East Anglia ONE North Offshore Windfarm

Appendix 10.1

Fish and Shellfish Ecology Consultation Responses

Applicant: East Anglia ONE North Limited
Document Reference: 6.3.10.1
SPR Reference: EA1N-DWF-ENV-REP-IBR-000347_001 Rev 01
Pursuant to APFP Regulation: 5(2)(a)

Drawing file: published-documents / EN010077-001130-6.2.10.21 EA1N ES Figure 10.21 Sprat Spawning and Nursery Grounds.pdf

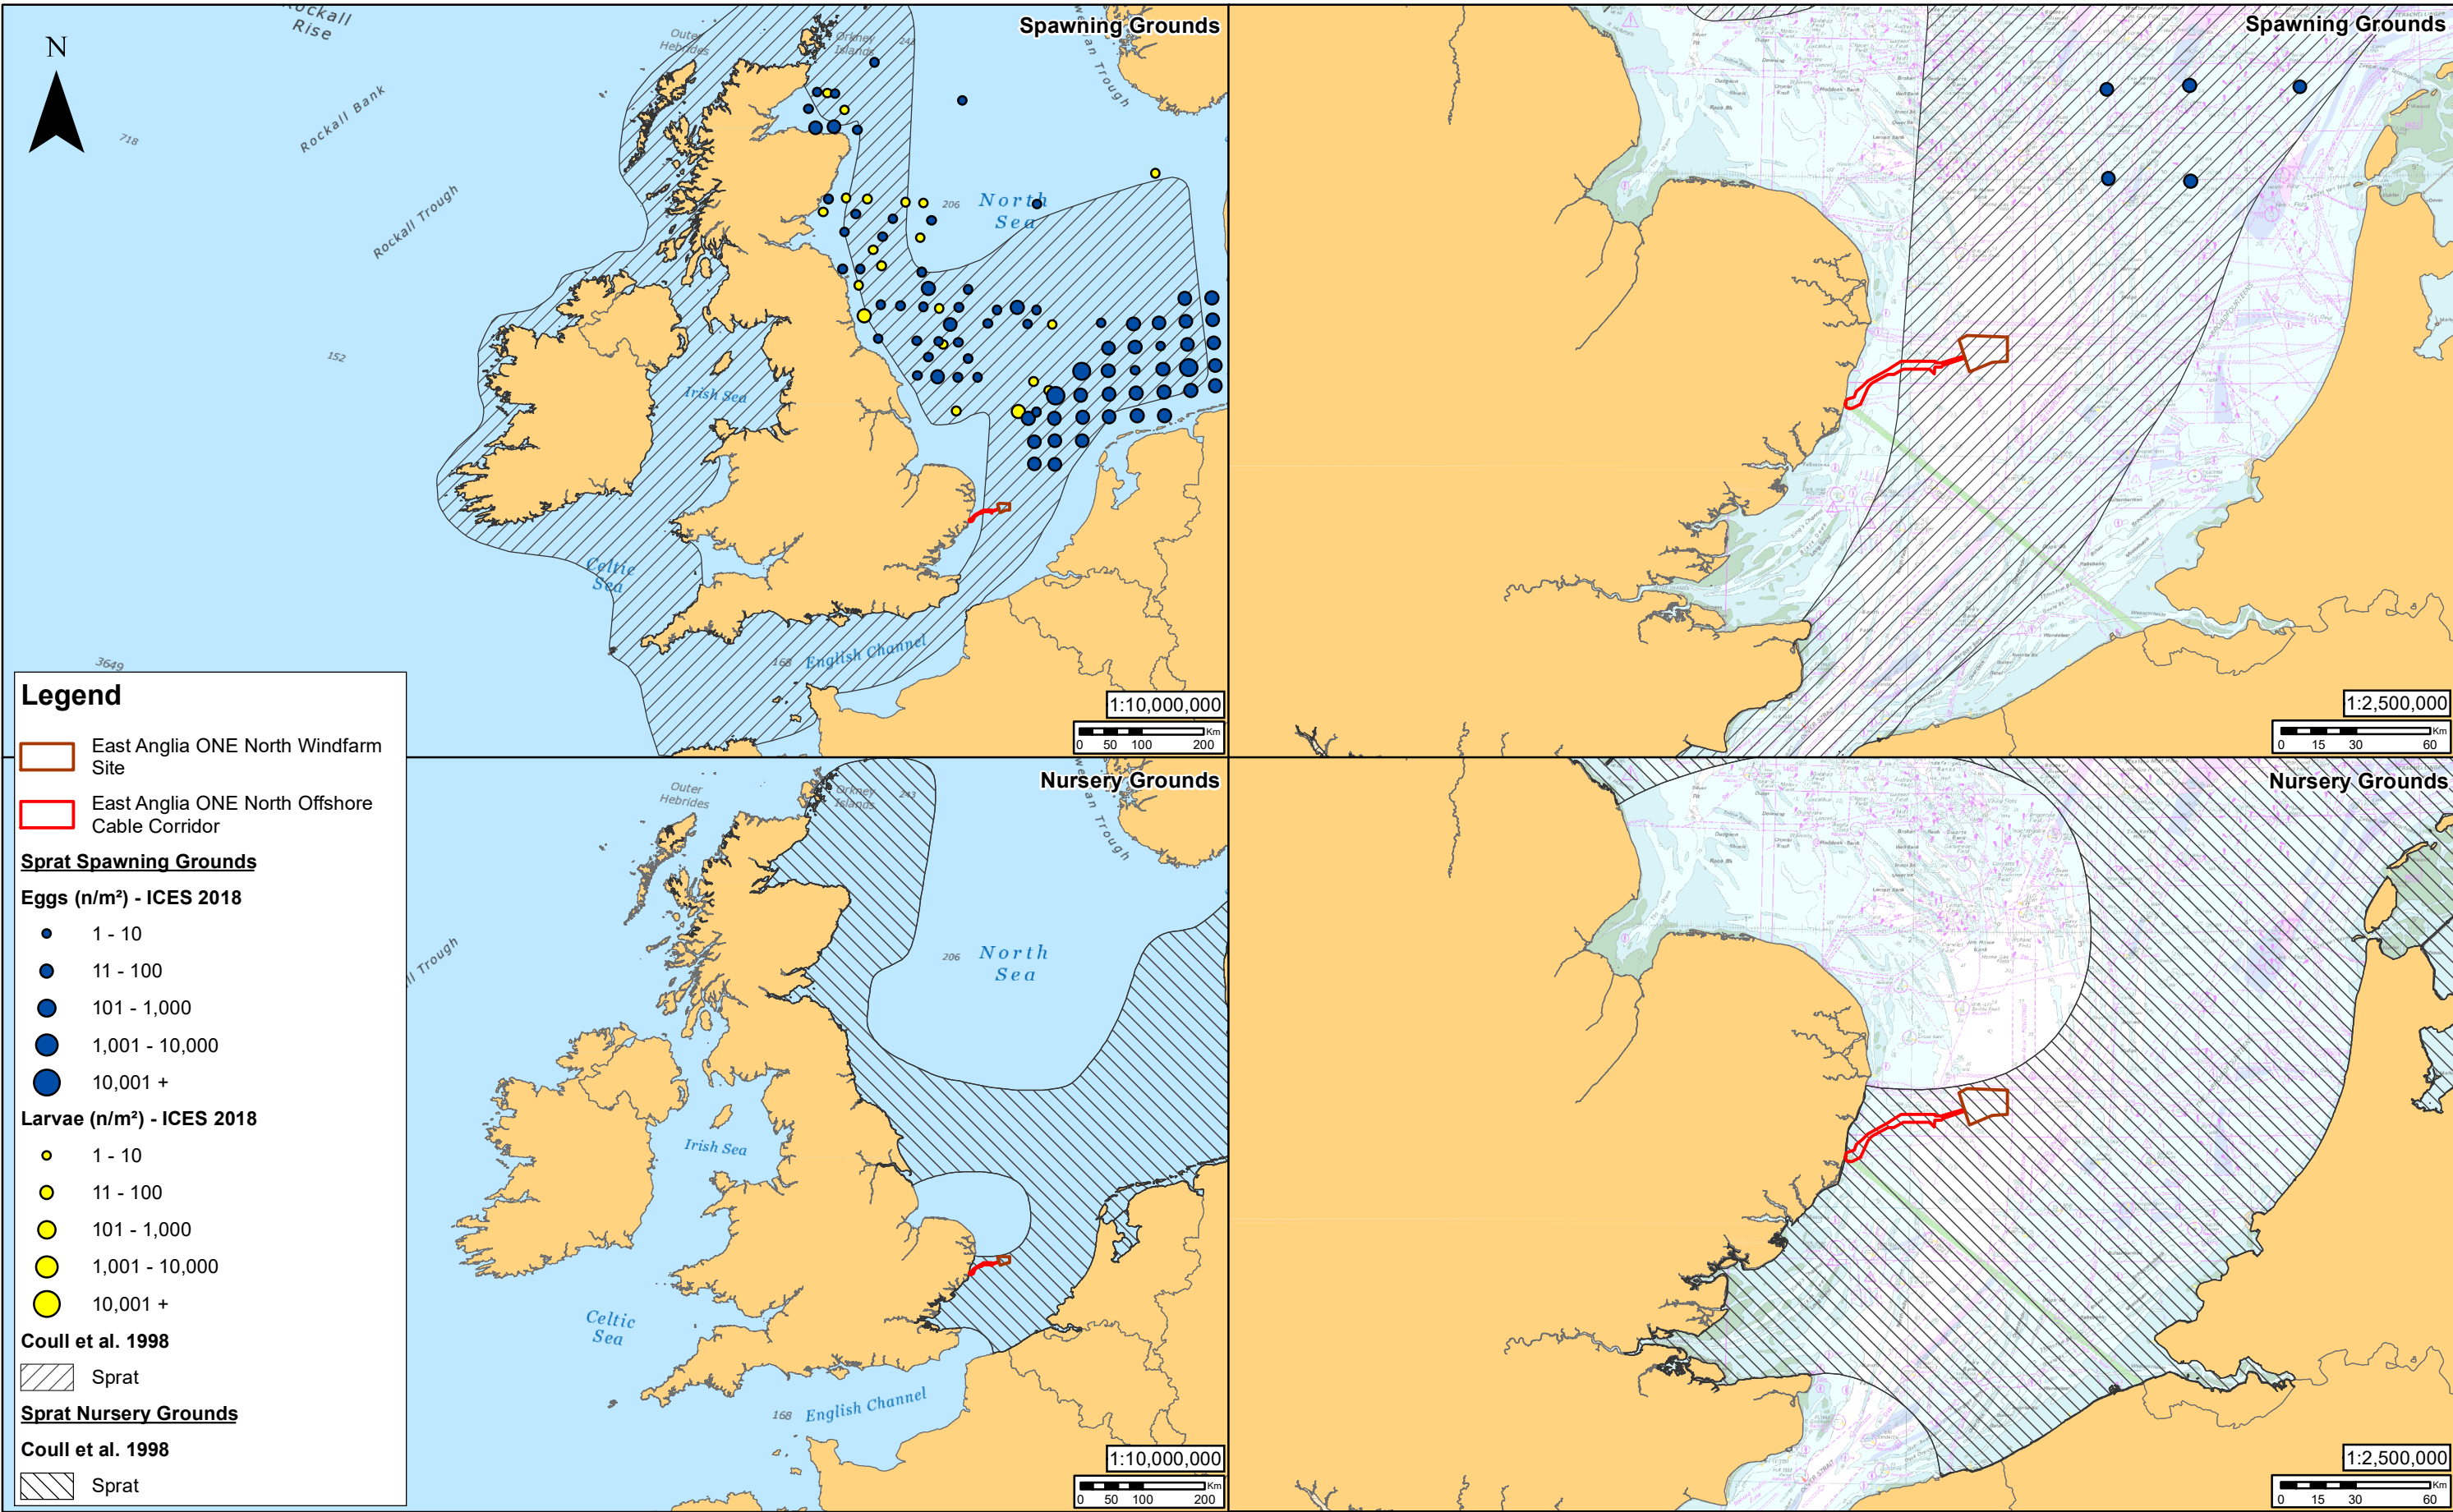
Consultee	Date/ Document	Comment	Response / where addressed in the ES
The following comments were received prior to consultation on the PEIR and were in response to the Scoping Report or direct consultation with stakeholders. These comments were taken into account in the production of the PEIR			
Natural England	08/12/2017 Scoping Response	As part of the evidence plan process NE [Natural England], Cefas [Centre for Environment Fisheries and Aquaculture Science] and MMO [Marine Management Organisation] advised EA1N and EA2 not to scope out re-suspended contaminants without site specific data to justify that contamination levels were low. We note that this has been provided and EA1N and EA2 are collecting site specific data, so this may be scoped out at a later date dependant on findings.	This is discussed in section 10.6.1 of Chapter 10 Fish and Shellfish Ecology .
Marine Management Organisation	07/12/2017 Scoping Response	The scoping report refers specifically to fish ecology only. Please could SPR confirm that potential impacts on shellfish will also be included in the ES.	Shellfish have been included in our assessment and addressed in section 10.6 in the chapter and Appendix 10.2 .

Marine Management Organisation	07/12/2017 Scoping Response	It should be noted that the proposed development is within a recognised spawning and nursery area for whiting and mackerel.	Noted, these species have been included in our assessment and addressed in Table 10.11 and Appendix 10.1
Marine Management Organisation	07/12/2017 Scoping Response	The MMO welcomes the recognition of the seabass special protection measures and confirmation that the PEI will consider important seabass habitats.	Noted, for further discussion regarding seabass habitats see section 10.5.4 in the chapter and Appendix 10.2 .
Marine Management Organisation	07/12/2017 Scoping Response	The Scoping Report recognises that there are areas of sandbanks inshore of the ECR corridor area of search which is supporting features of the Outer Thames Estuary SPA which are of importance to foraging red throated diver <i>Gavia stellata</i> . Sandeels are a prey	Section 12.5.3 of Chapter 12 Offshore Ornithology indicates that sandeel are a prey species for various seabirds which may be impacted by the proposed East Anglia ONE North project, as discussed in section
